Your Ref: planning application P/58/19/PL

With respect to the above planning application we make the following observations.

The access to the Inglenook Hotel car park and the proposed development of 9 dwellings at the rear is not fit for purpose, given that;

Visibility Splays and Internal Swept Path Analysis

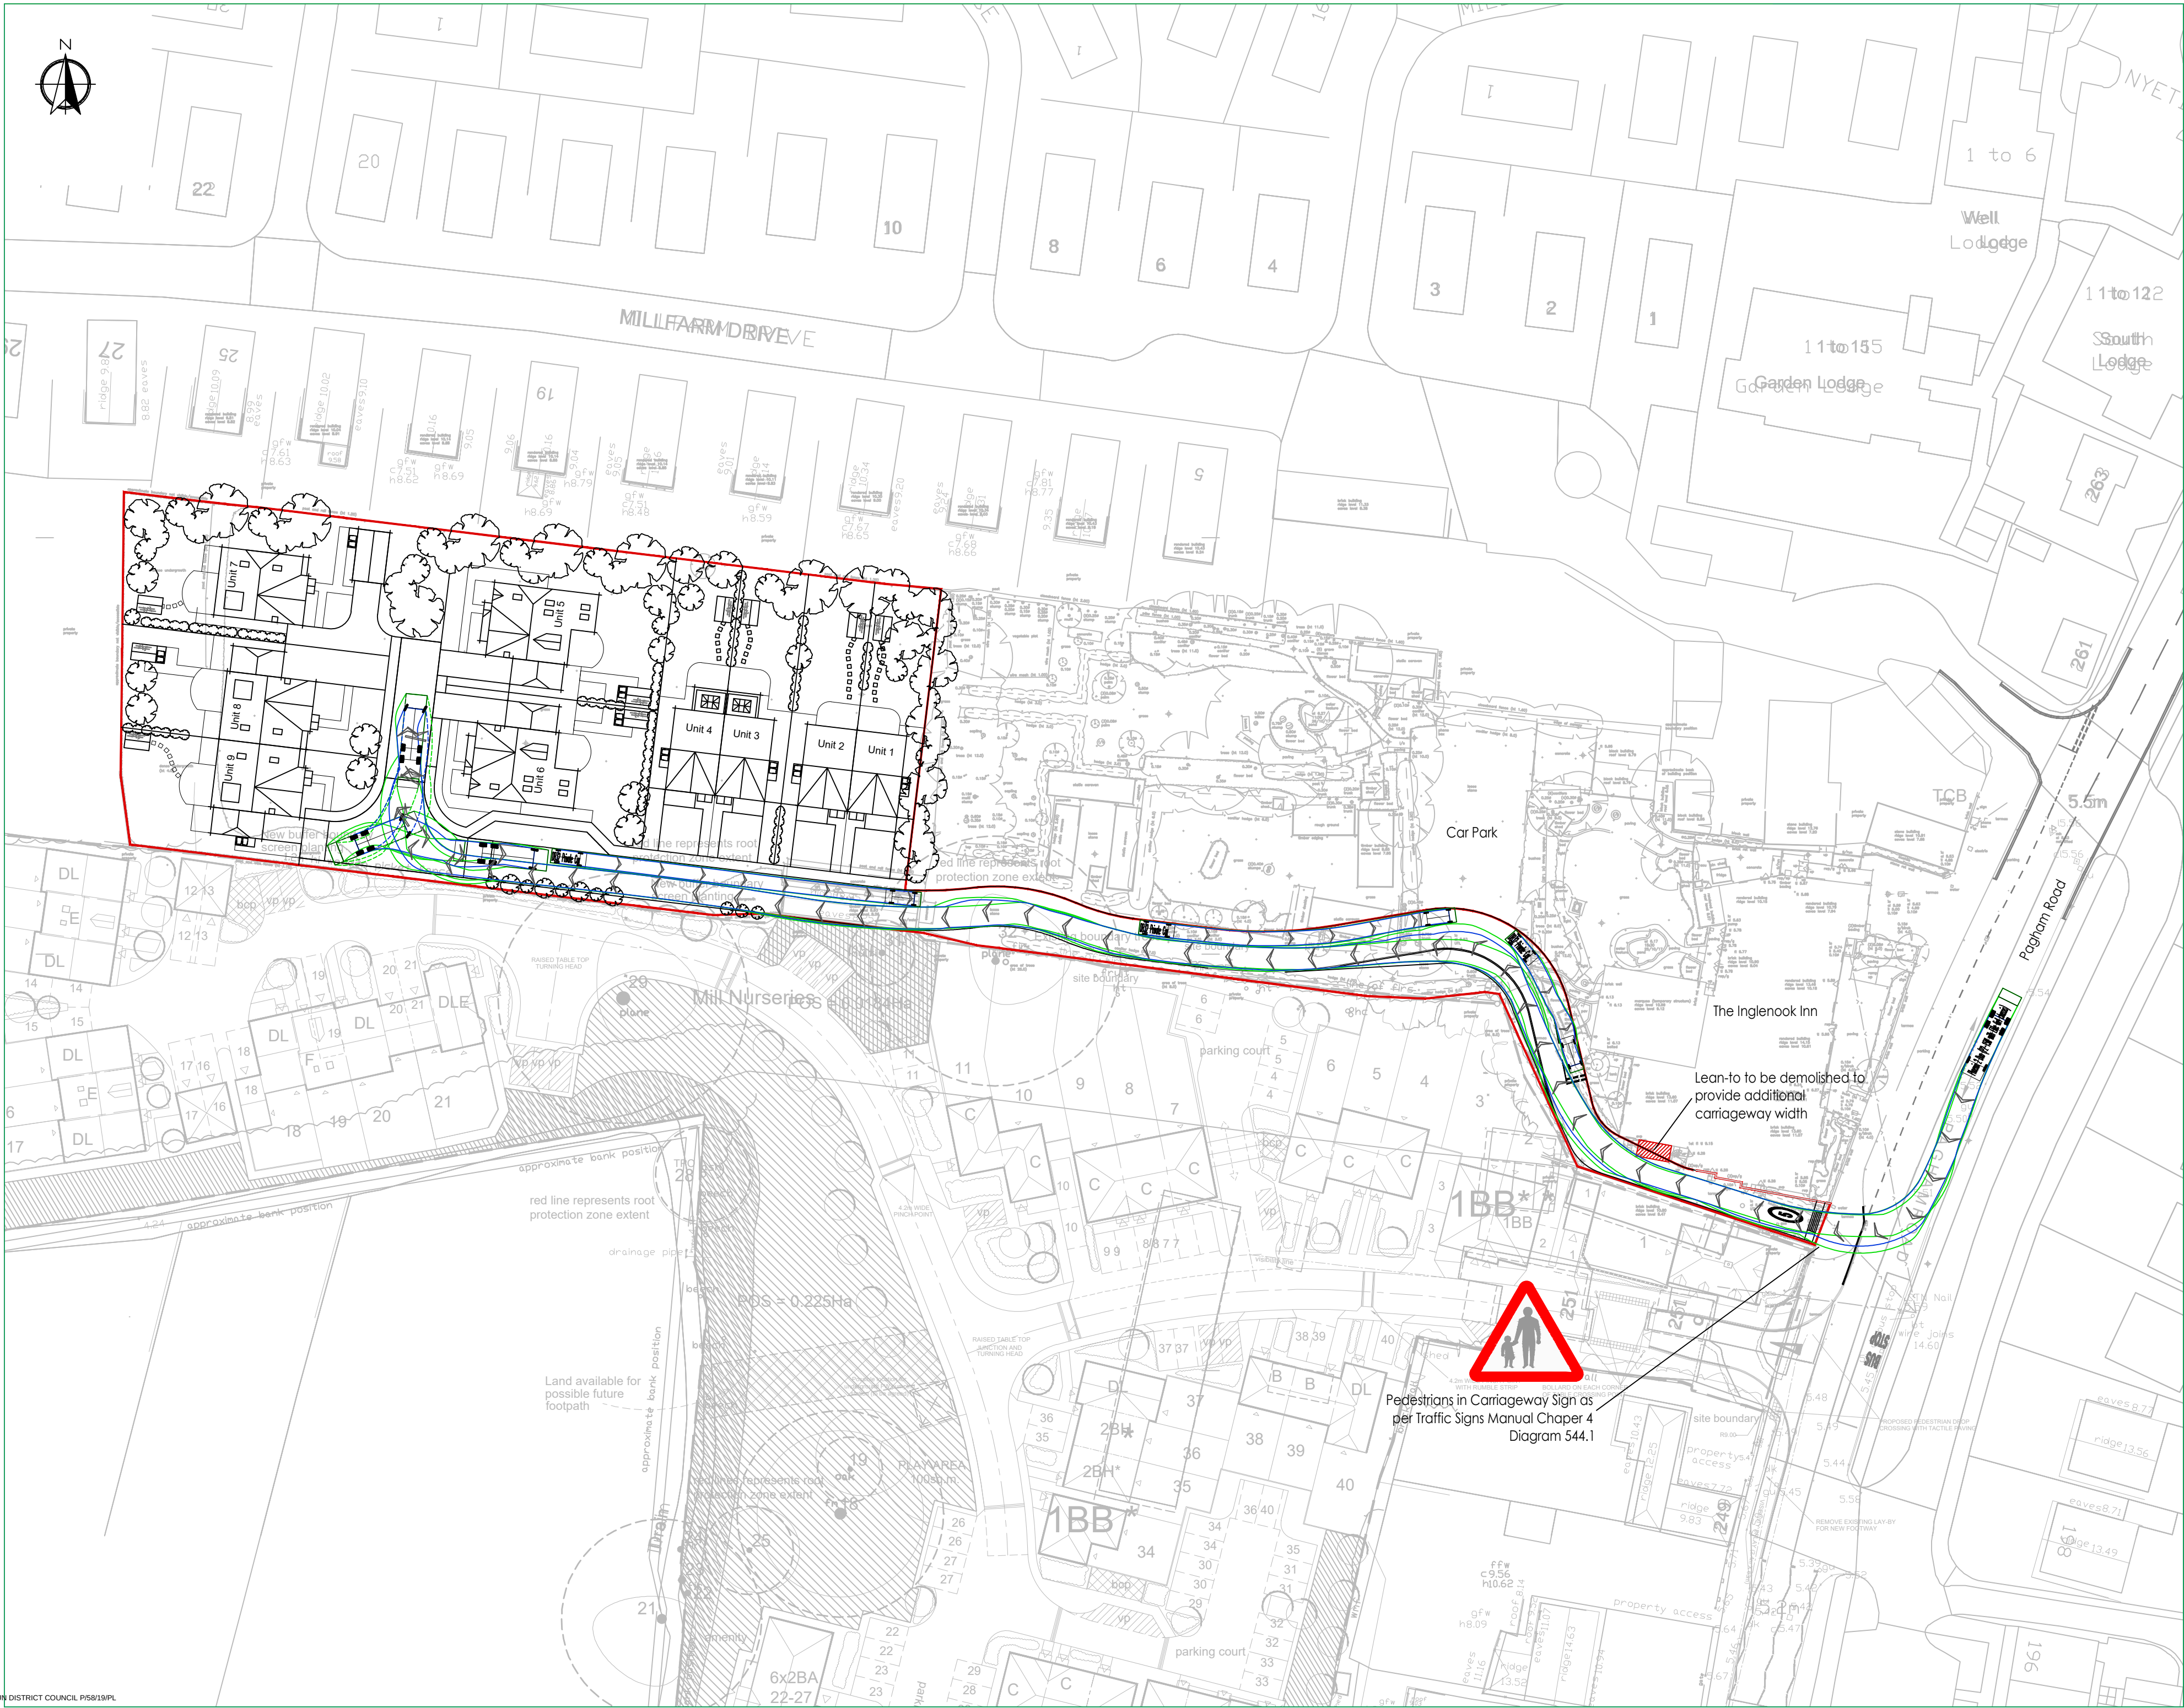
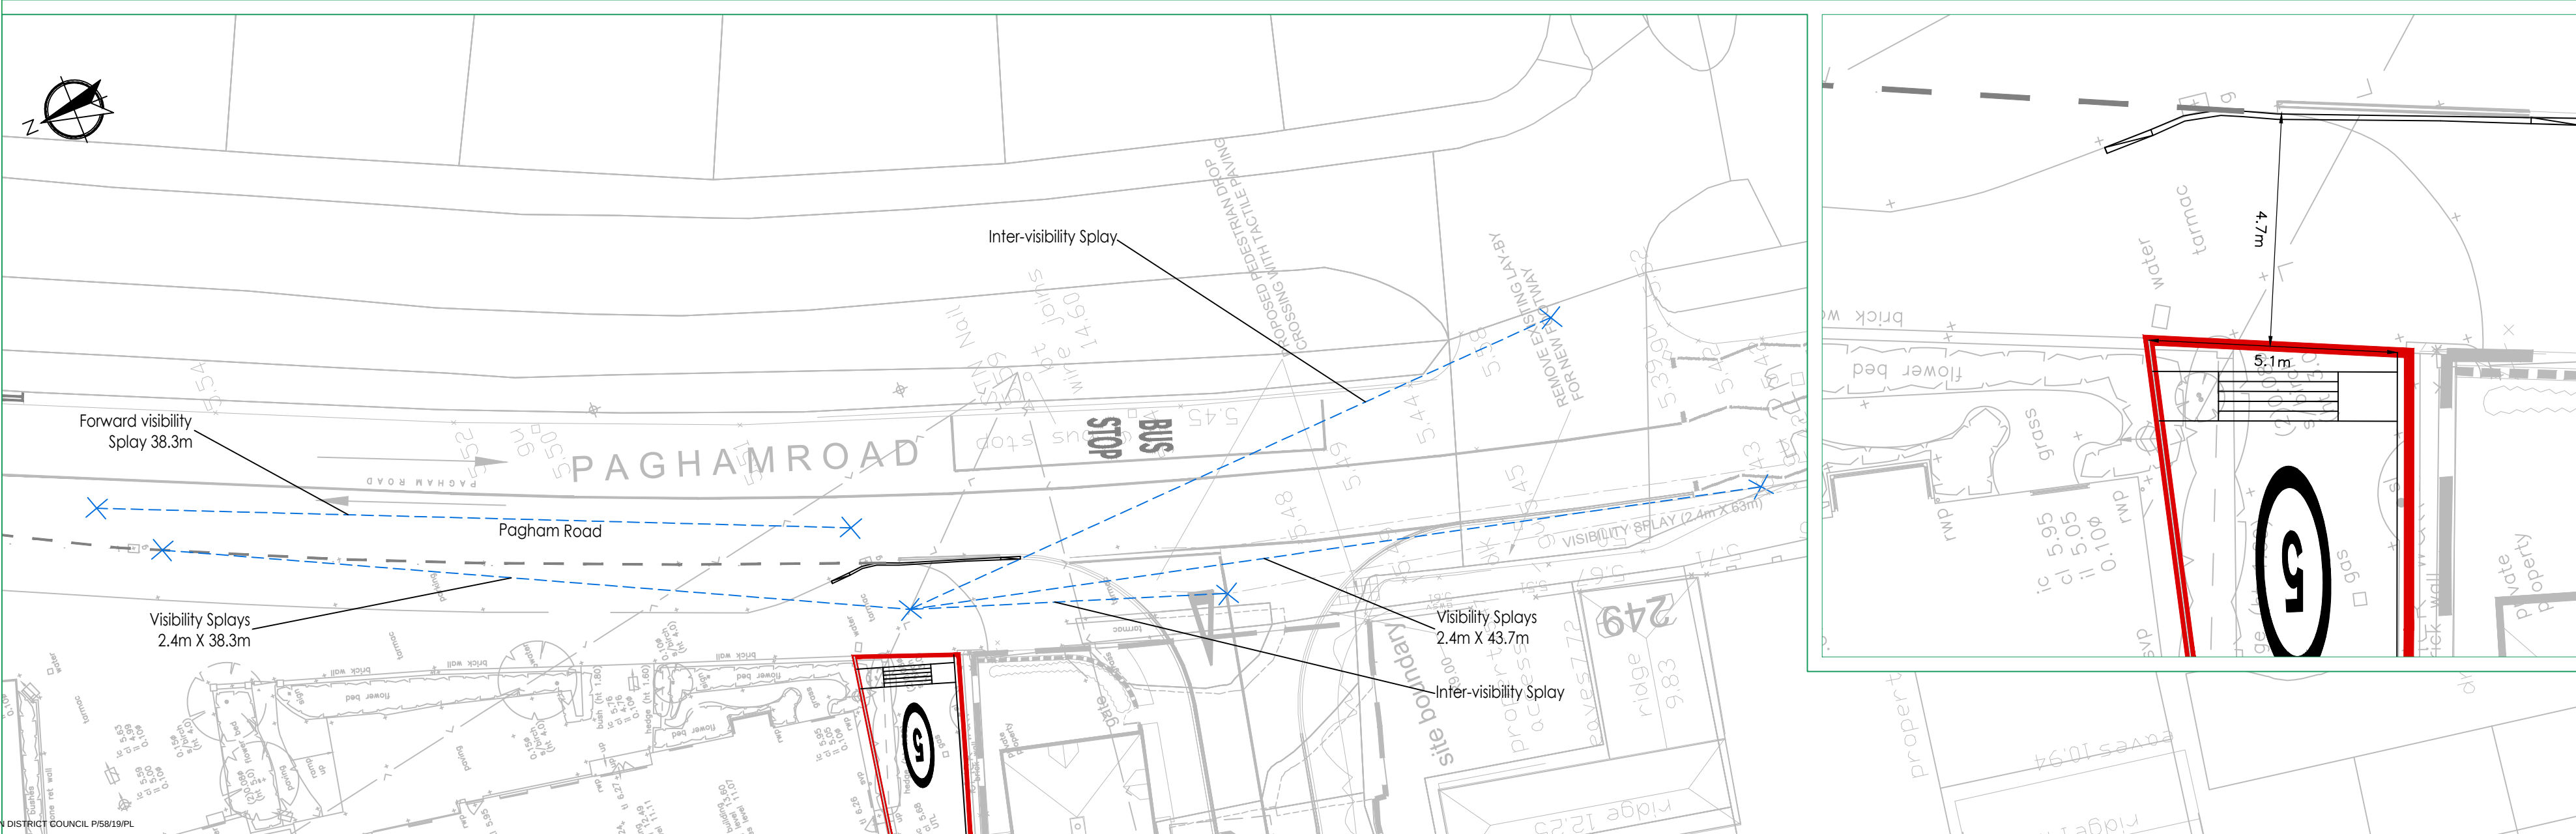
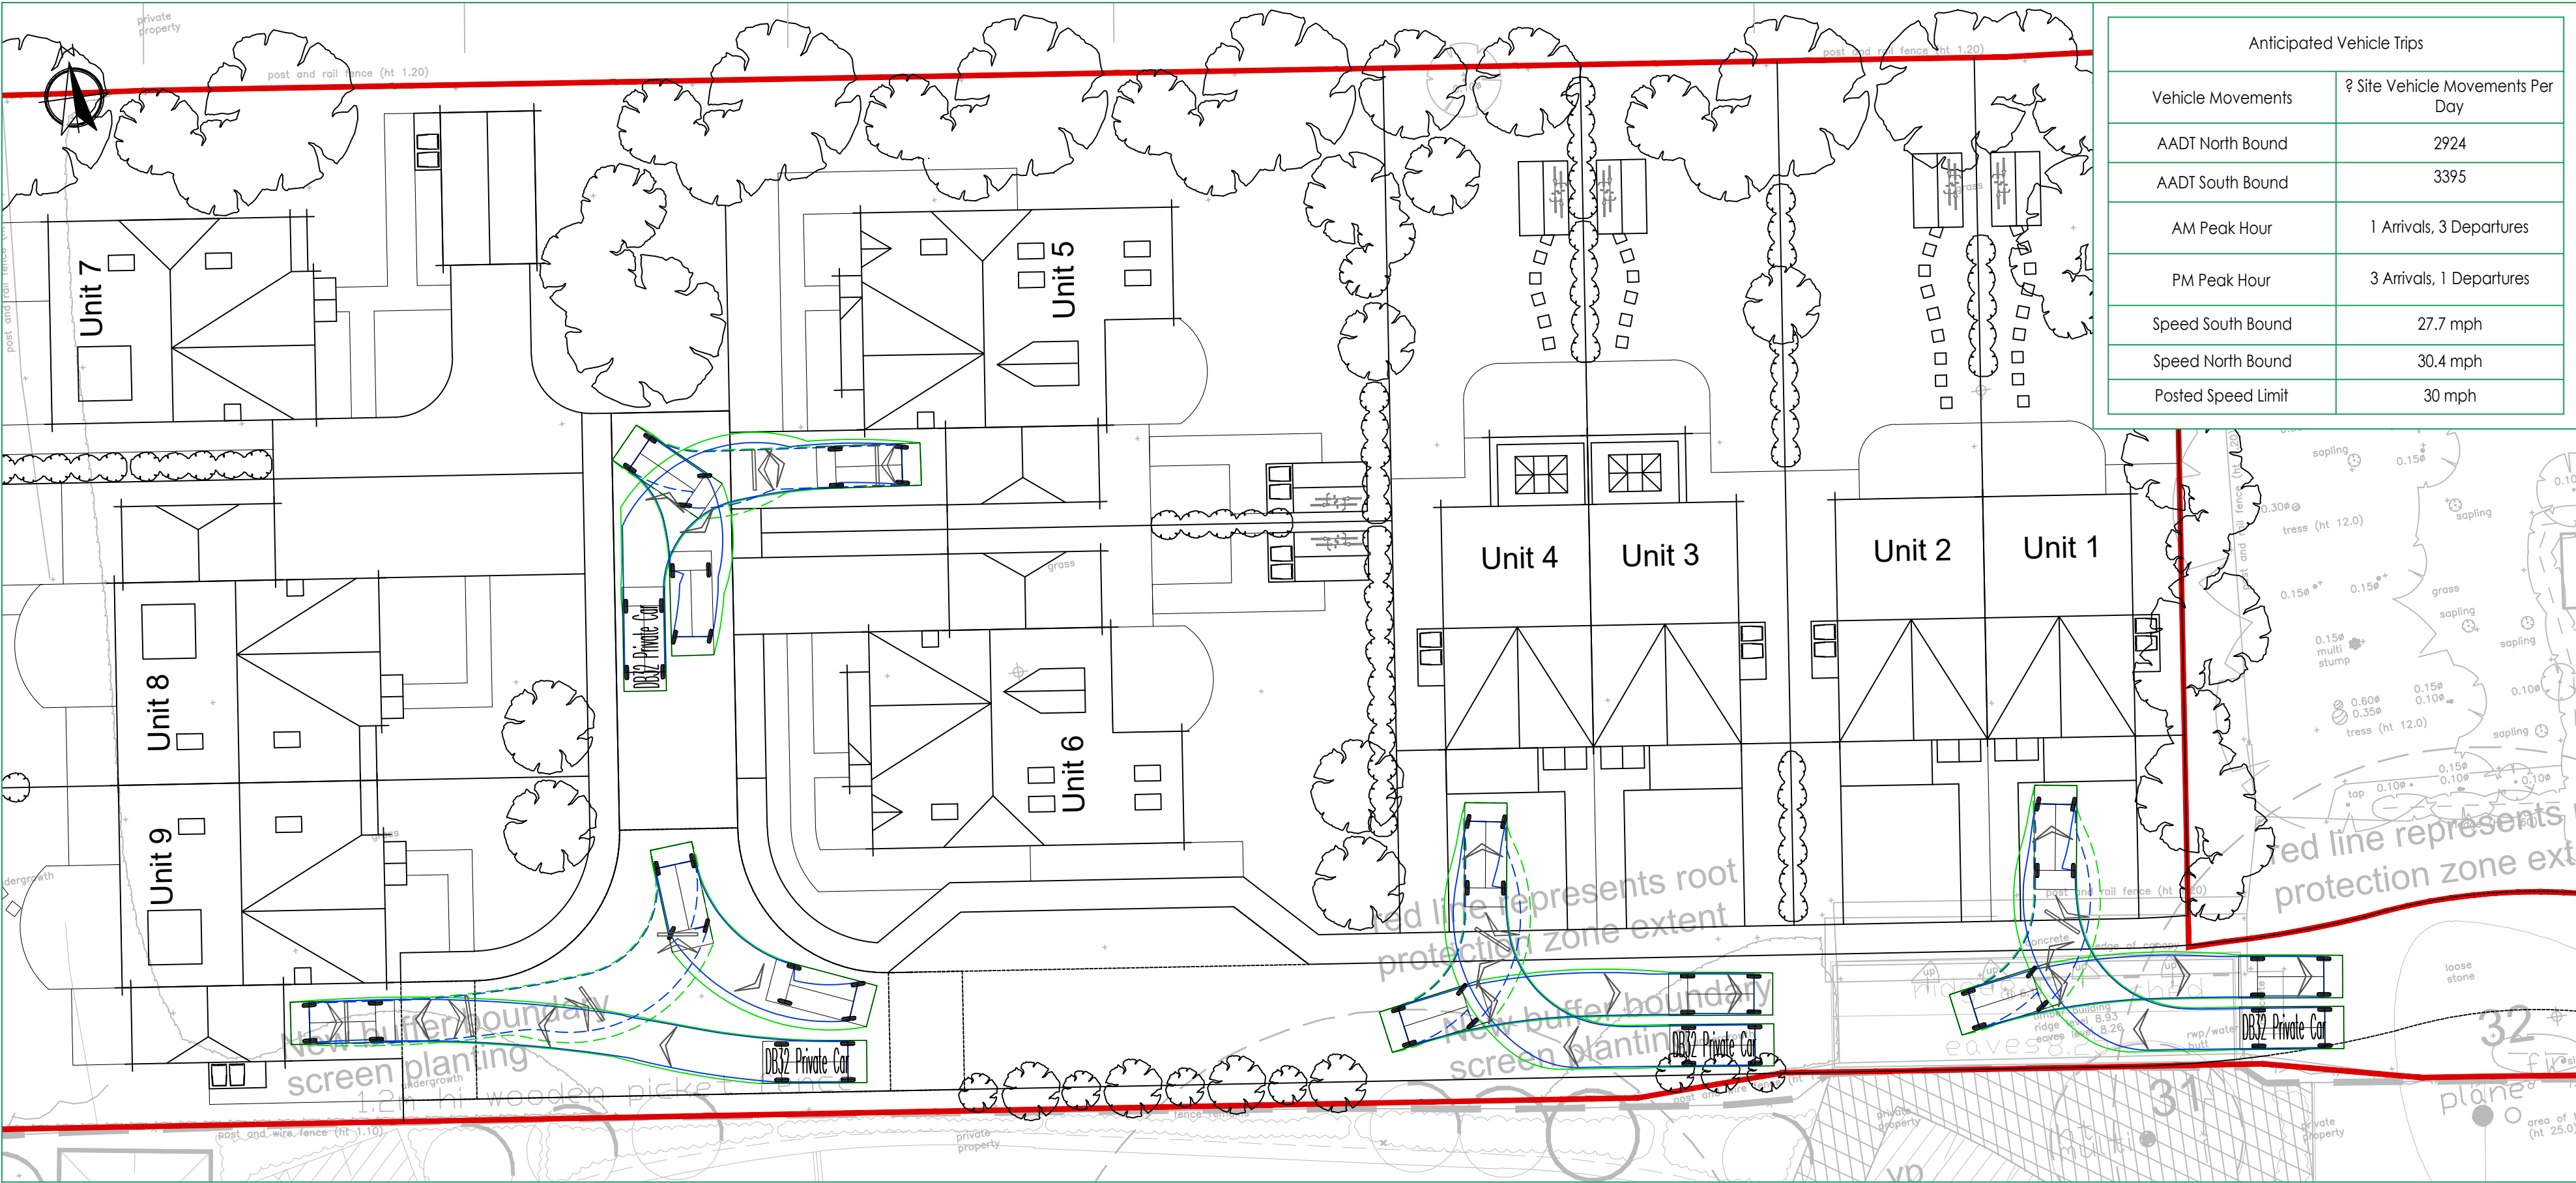
There is insufficient vision on the bend, it will end up with vehicles having to reverse one way or the other, thereby putting pedestrians at risk ( particularly children on foot or on a cycle, also it could be a mother with a pram.

There is insufficient room for a designated footpath, my understanding that the new dwellings are family home therefore will have children. For their safety the access must therefore have a designated footpath.

To say signs directing vehicles to drive slowly in the access road is a nonsense, in Pagham road there are 30mph signs also a illuminated sign and drivers still drive well in excess of the speed limit, 40mph plus. We all know how the white van delivery drivers perform, by the way they get paid speed is of the essence.
